Cricket Centre - State Significant Development SSD-10354

Agency Submissions

Figure 4. Maximum Flood Depth Results during a 100-year ARI Flood Event in Post-development Condition

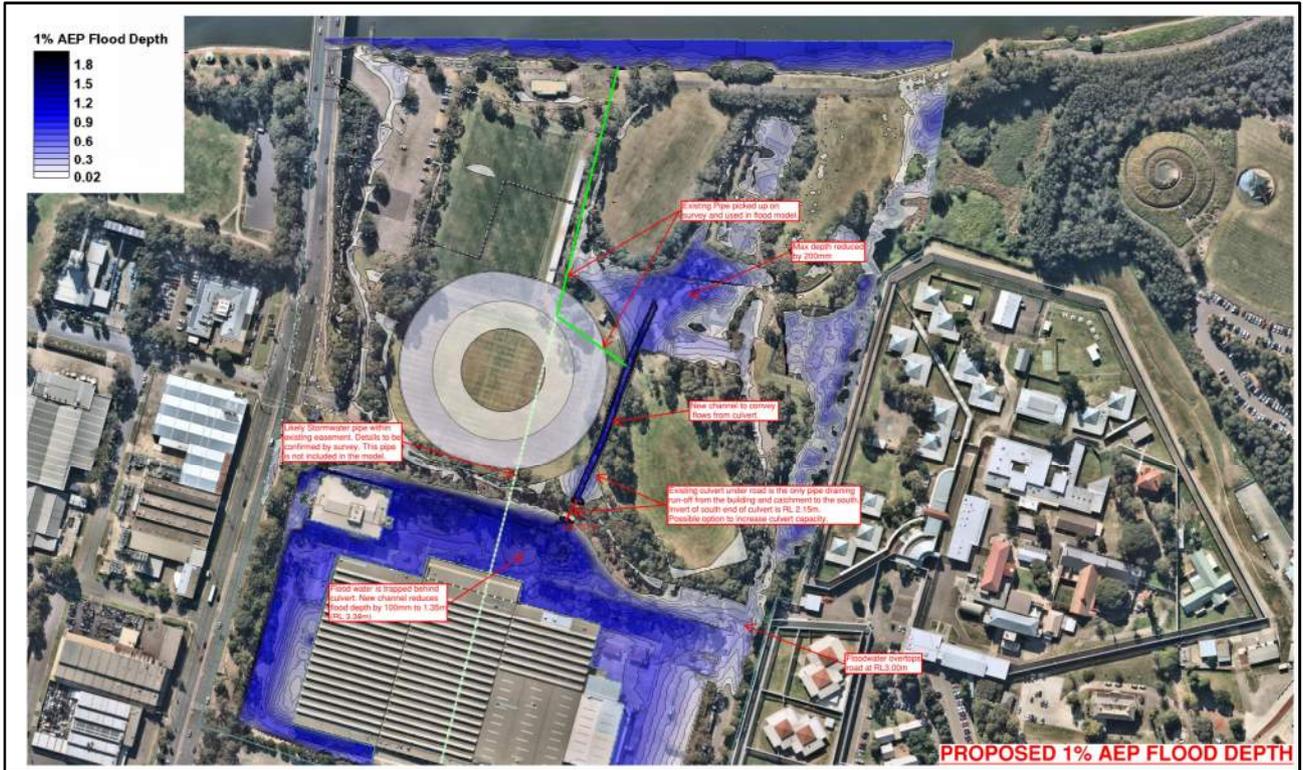
39	<ol style="list-style-type: none"> 2. The post development flood scenario should not consider the contribution of pipe unblocking to mitigate the development's flood impact. 	The blocked flood scenario has been analysed and the proposed development does not worsen the existing condition as noted in the Stormwater and Flooding report.
40	<ol style="list-style-type: none"> 3. The flood impact assessment must be expanded to detail measures to address the floods risk of the development including excavation, fencing and signage. 	The detailed measures such as signage and fencing will be addressed in the Flood Management Plan (Attachment I).
41	<ol style="list-style-type: none"> 4. Any bridges or culverts over the overland flow channel should consider potential for blockage in accordance with Australian Rainfall and Runoff (AR&R) Guidelines and also provide a reliable evacuation path to an area of refuge above the PMF. 	Blockage will be considered for the road crossing in the PMF event for the site. Our Flood Impact assessment report shows the development site at 5.2m RL FFL is above the 100 year flood level of 3.31m AHD. We will assess against the PMF. The area is identified as low risk on previous assessments and the proposed centre of excellence looks to be above the PMF level of about 5.0m AHD, to be confirmed. Shelter in place is our preferred strategy.
